Planning Application Ref: AL/27/20/PL

Location: Springfield and land to rear, Hook Lane, Aldingbourne, PO20 3TE

Description of works: Demolition of the existing dwelling & construction of 2 No. 2-bed, 3 No. 3-bed & 4 No. 4 bed houses including access, landscaping & associated works (resubmission following AL/51/19/PL).

Mark Warwick
Tree Officer / Parks and Greenspace Team

Proposed Block Plan 1:500@A3

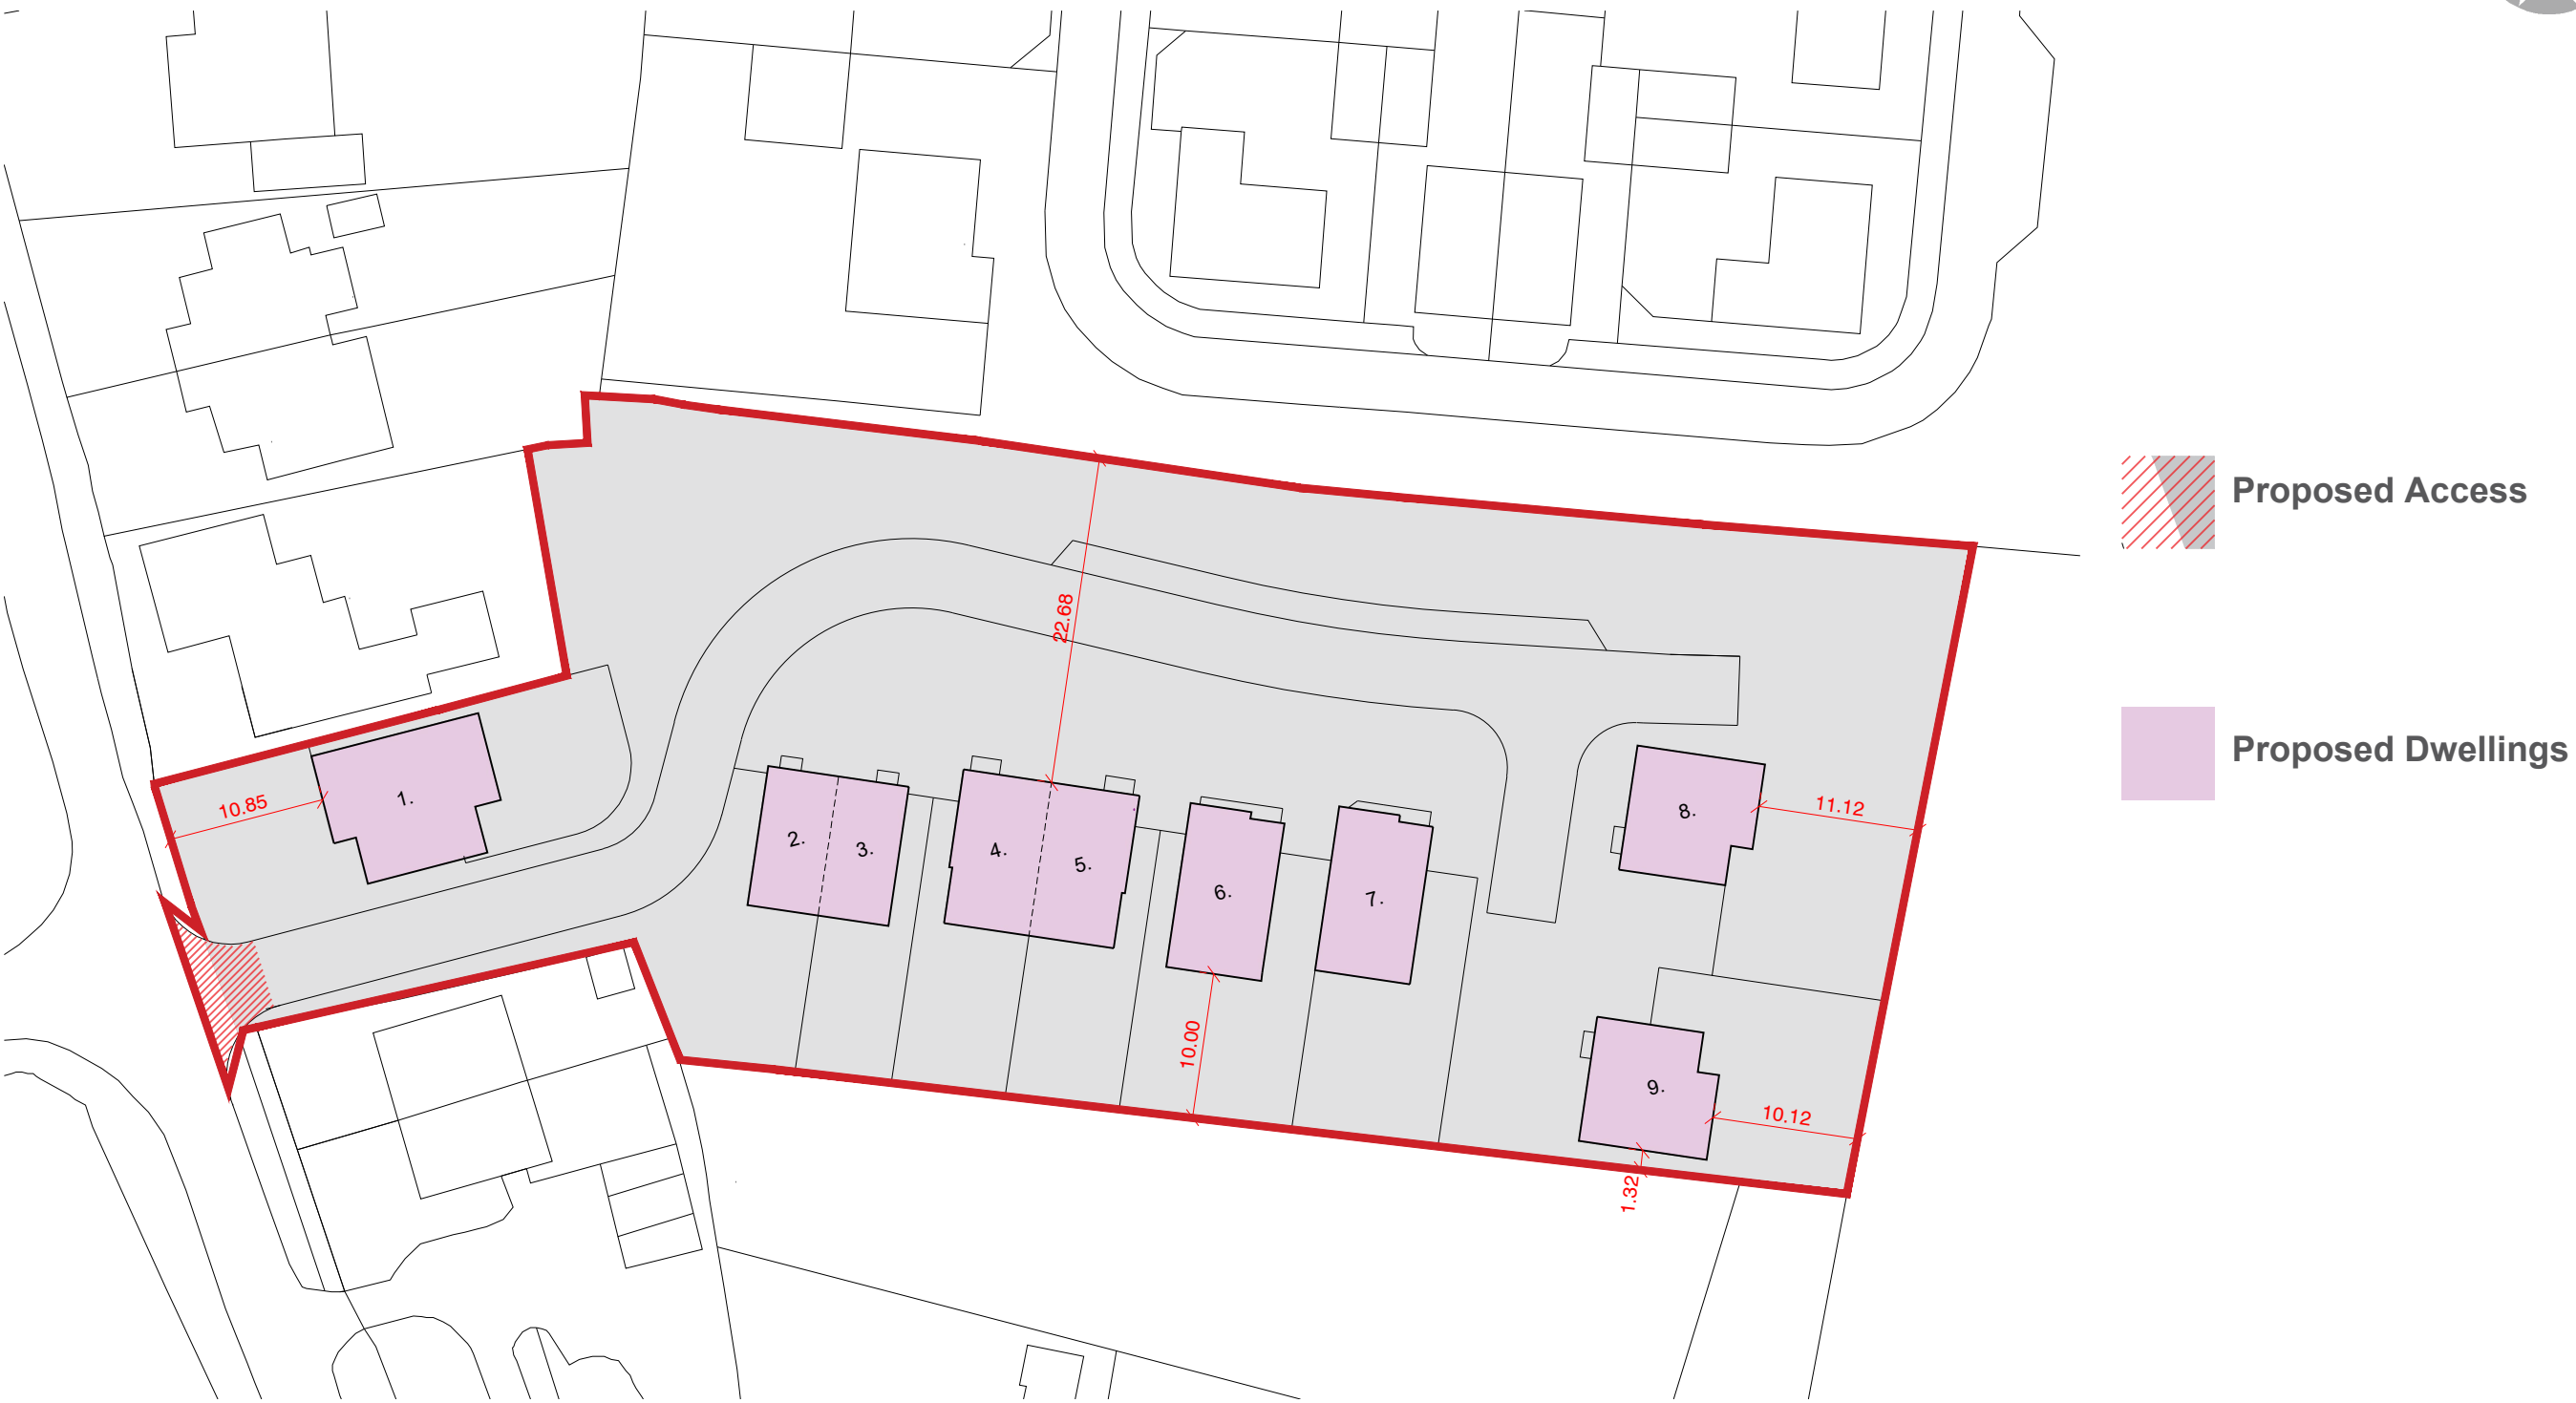
- In broad terms, the proposal as it stands can only be implemented by removing the majority of large evergreen trees, that are of obvious landscape value. A number of these have also been identified as Category B trees, a rating I can comfortably support.

- There does not appear to be a surface water drainage strategy for the site, only a statement of broad intent. This fundamental element of the design ought to be addressed to our satisfaction in association with layout proposals, so that we are not subsequently held hostage to flood mitigation measures which could then impact heavily on retained trees and landscape plans. I believe this element critical to the success of any development at this site - the most recent proposal (in support of AL/51/19/PL) involved unacceptable (potentially catastrophic) intrusion within the root protection area (RPA) of a Category A oak (also the subject of a Tree Preservation Order, TPO/AL/1/20). We must know where the soakaways, attenuation tank(s) and drainage route out to the existing waterway (north boundary) are to be located.

- Foul water and other service-runs in and out of site have not been shown, so potential exists for additional RPA incursion to satisfy those requirements.

- The proposal seeks to fully exploit the available space but without sufficient regard for the highest quality trees existing; the majority of which could be retained in harmony with and provide instant value to a more sympathetic design. To achieve this most desirable outcome, I suggest further revision of the plot layout/numbers would be required, perhaps in conjunction with a re-alignment of the access road closer and parallel to the south boundary – thus eliminating substantive RPA intrusion of and capturing those north boundary trees within extensive rear gardens.

Tree Constraints Plan
Springfields, Hook Lane, Aldingbourne, West Sussex

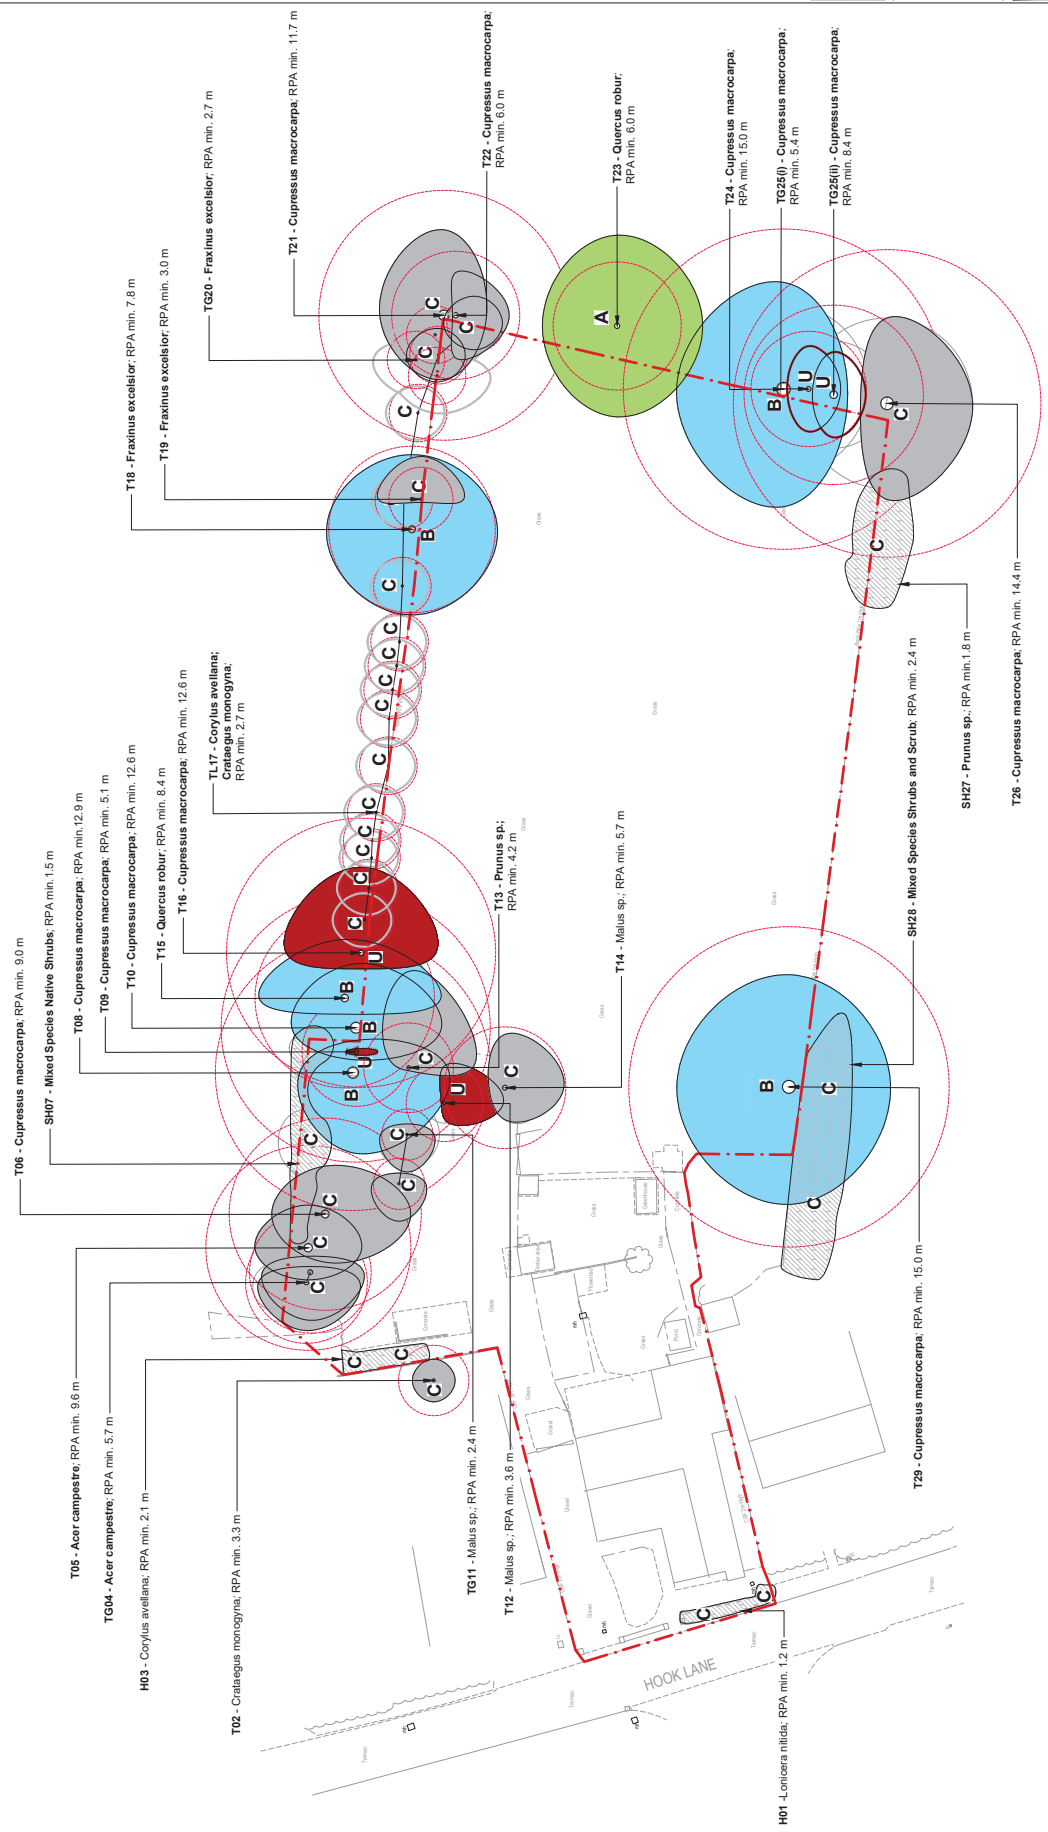
- The Tree Survey data is comprehensive and accords with the requirements of BS5837:2012. I am broadly in agreement with the retention category ratings for on and off-site trees, although I detect a tendency to undervalue a number of trees identified as Category C (low quality) that might qualify as Category B (moderate quality) and should therefore have greater influence over any site layout proposal.

- The high canopy Monterey cypress, old native maple trees and other established trees (albeit of low quality) along the north boundary add a mature outlook and provide visual amenity to the surrounding area. They will no doubt be of considerable value to those occupying new dwellings to the north (Barratt Homes development) and beyond. Extensive intrusion into root protection areas of those cypress and a developing oak (all Category B) will be required to facilitate construction of the access road. This is high risk work and demands regular on-site supervision by the project arboriculturist. If this development were to proceed as described, then appropriately supervised installation of the 'No-dig' sections would have to occur and before any other substantive groundwork or construction of dwellings occurred. It may be necessary for a 'sacrificial' layer of the cellular confinement system (Cellweb or other similar product) to be employed throughout the construction phase.
